21/08/2019

Loreto Normanhurst School Redevelopment (Concept Proposal and Stage 1) (SSD-8996)
Request for response to the Department's key issues

ATTACHMENT 1: Key Issues

Drawing Title
**OVERALL 3D VIEW -
FUTURE PROJECTS**
Sheet Status
NOT FOR CONSTRUCTION

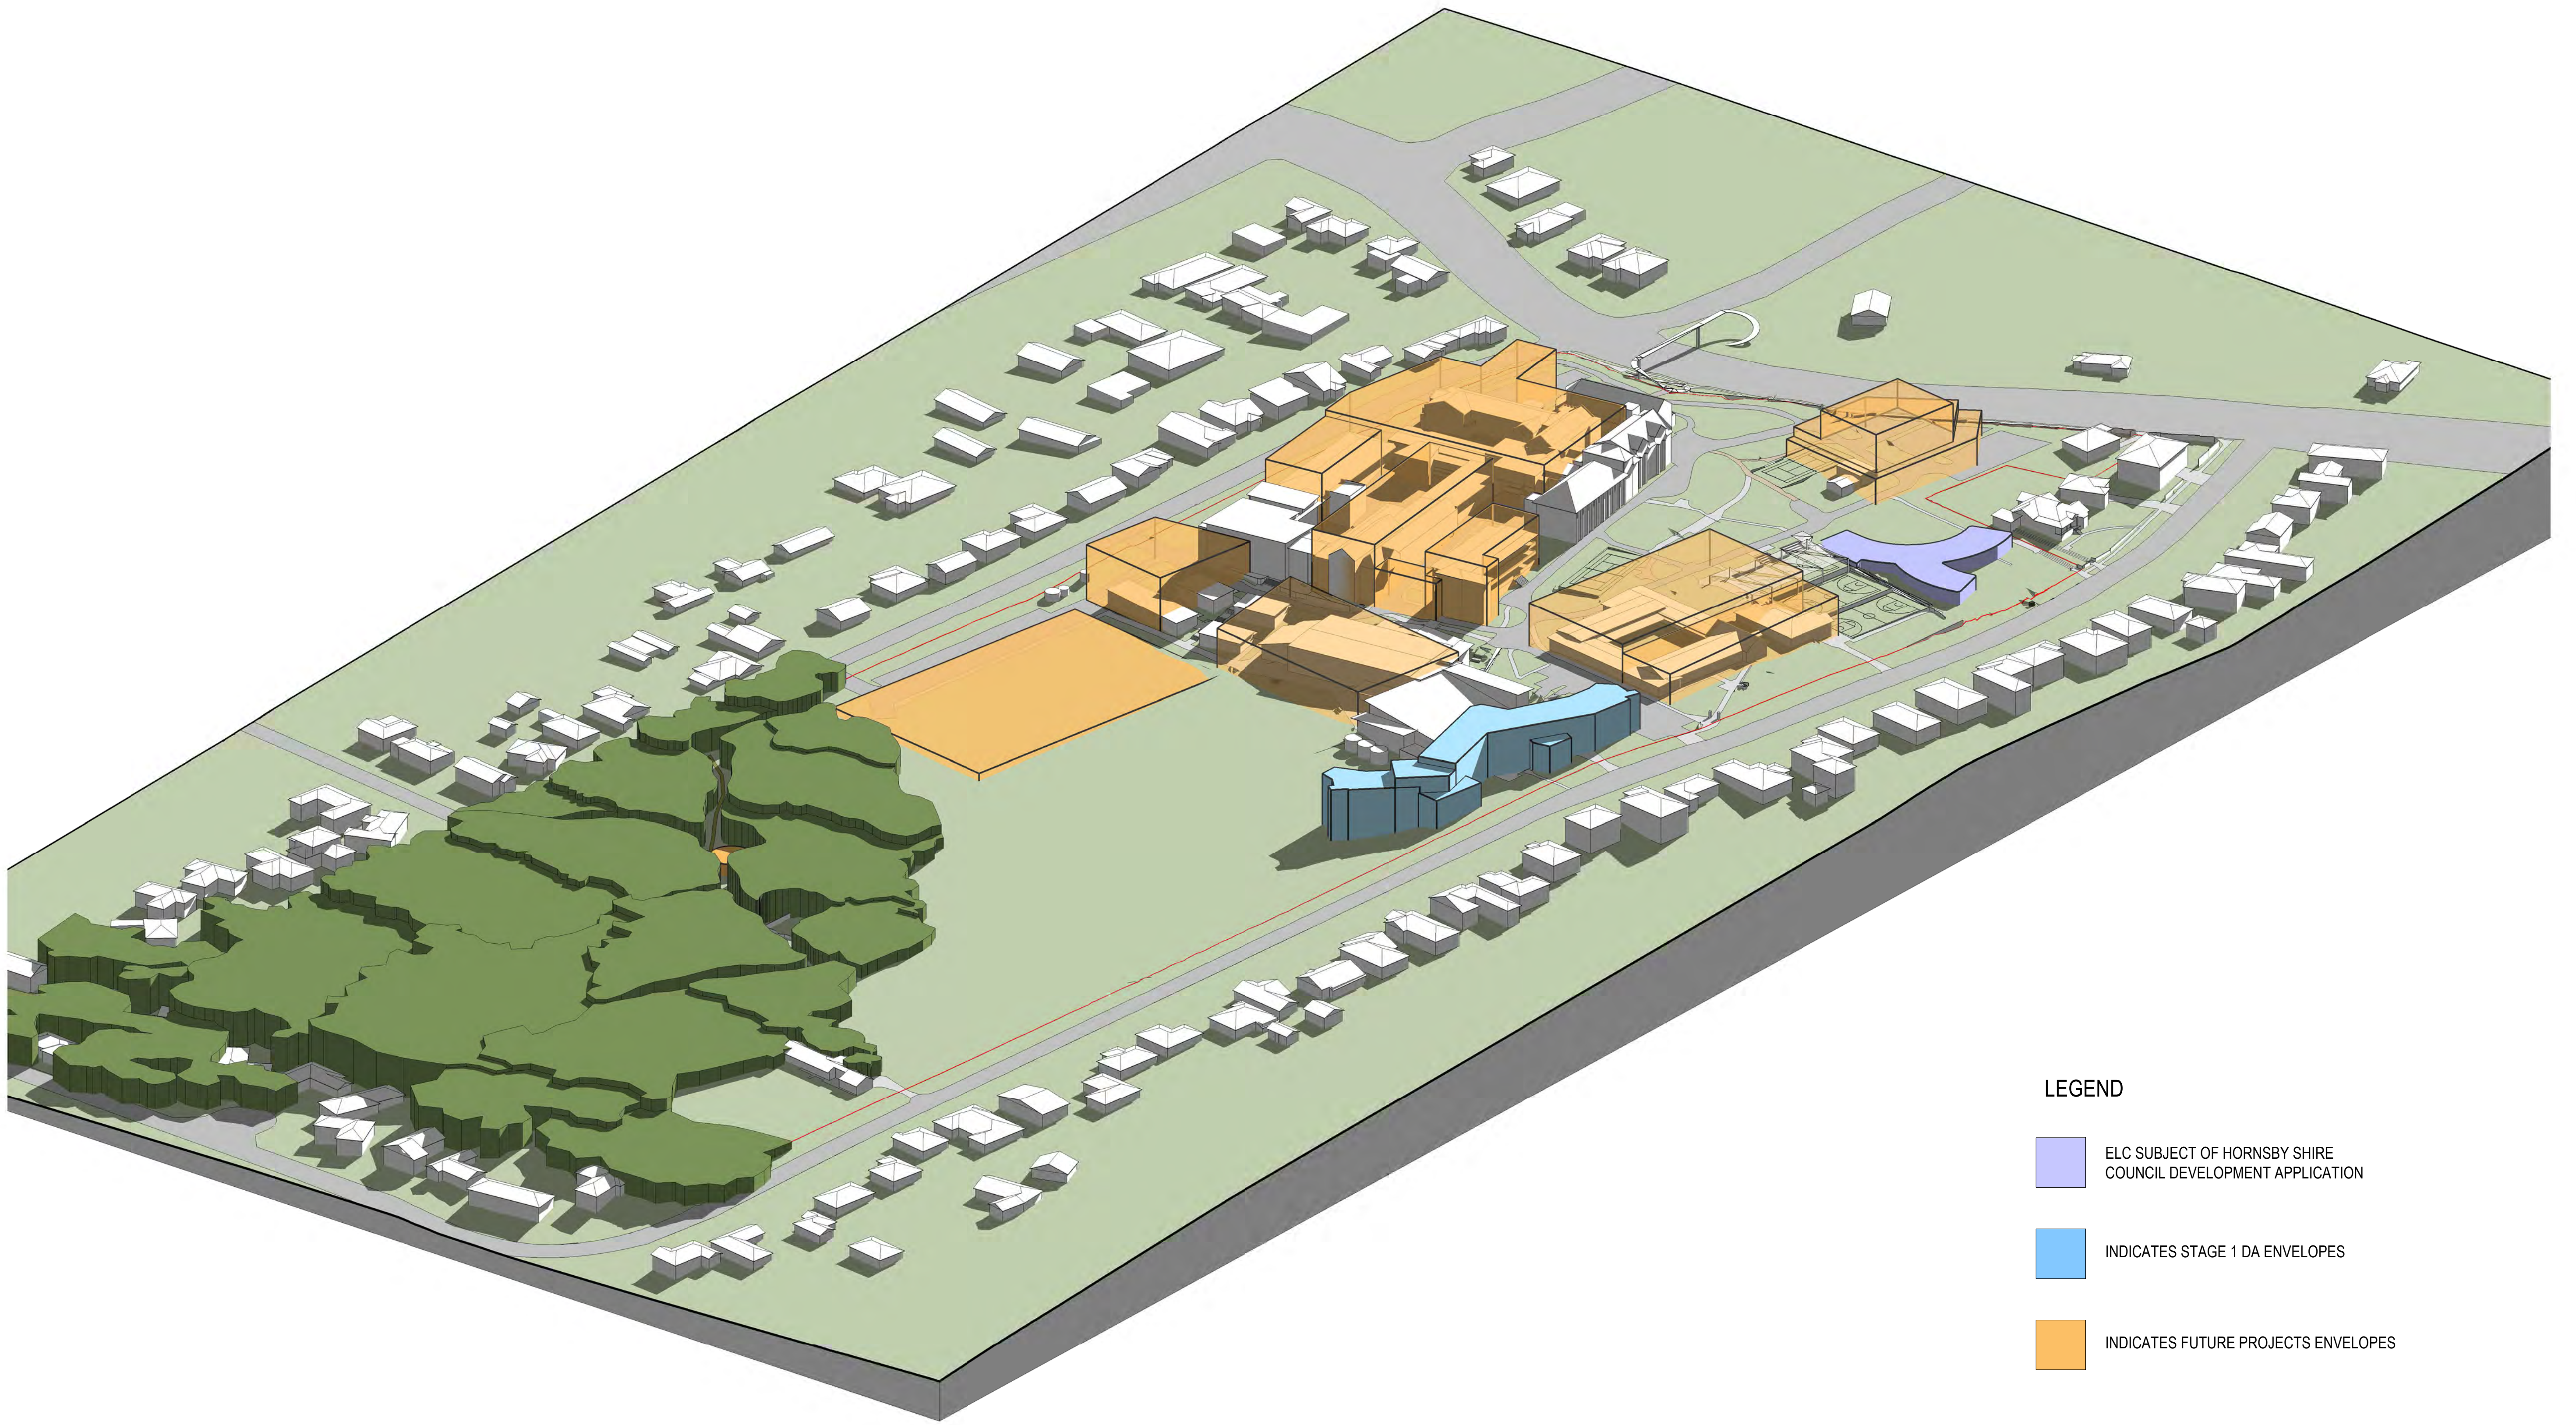
- The maximum building envelopes are proposed with no variation to the building heights. The proposed envelopes, in particular Envelope 2 and 3, would dominate the significant heritage elements of the site, as well as the surrounding low-density developments.

- The current Conservation Management Plan for the site (CMP 2008) discourages structures to the north and to the north east of the chapel. The concept proposal proposes a large six storey building envelope (envelope 3) in this part of the site, which is sited forward of the heritage listed buildings and within the curtilage of the heritage listed school gate. The Heritage report submitted with the states that the impacts are acceptable, subject to detailed design. The Department is concerned regarding the apparent inconsistency with the CMP. The Department is not supportive of the inconsistency with the CMP being justified on the basis that it can be dealt with by architectural detailing at a later development stage.
